Planning Services Sign Permit Review Form

Date of Submittal	Application Number	Applicant	Landowner
1/23/2024	SIGN2401-0003	Sign and Awning Systems Inc.	Allied Investors, Inc.

Contact Person	Contact Number	Sign Location	PIN Number
Rachel Taylor	910-892-5900	North Elevation	9586-88-3426.000

SMART SPACE STORAGE Flush-Mount Channel Letters w/ Logo Cloud

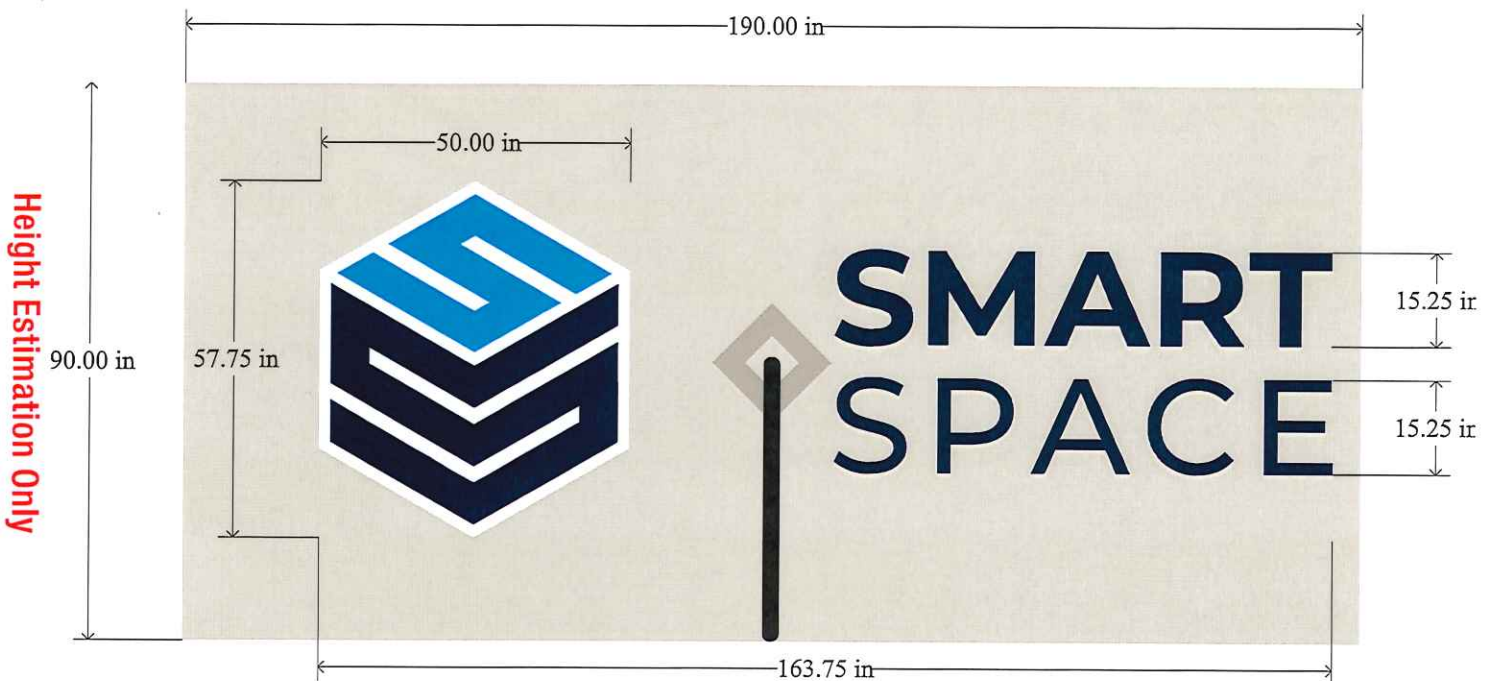
Comments	<p>1. The decorative background wall and the canopy shown in the sign rendering are existing architectural features approved in site plan review as an shown in the plans from the commercial building permit below. These are not being installed as a part of the sign. This sign permit only includes the channel letters and logo, which has a total of 65.69 square feet.</p>
----------	---
